**Consultation Response from KC,
Lead Local Flood Authority**

2026/90860 adj, 33, Sackville Street, Ravensthorpe, Dewsbury, WF13 3BX

Erection of 2 semi-detached dwellings

Date Responded: 20/05/2026.

Figure 4: EA Surface Water Flood Map

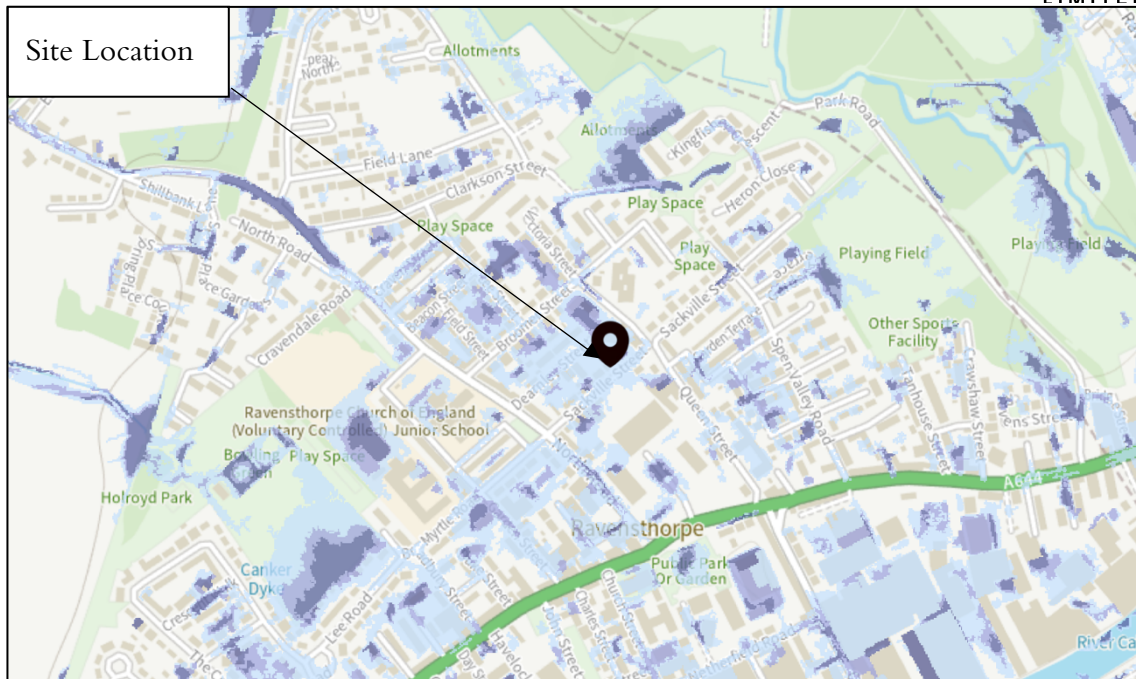
The LLFA agrees with the assessment in the FRA that the proposed development is appropriate and is not subject to an Exceptions Test (Flood Zone 2/More Vulnerable Flood Risk classification) and that the site is at **significant risk*** of surface water flooding (Groundsure Flood Report, Appendix B of the FRA).

*** Note:** Kirklees Council mapping indicates that the site is at risk of flooding from surface water as follows:

- 1 in 30-year rainfall event; up to 600mm deep over the north-western part of the site.
- 1 in 100-year rainfall event; up to 900mm deep at the centre of the site.
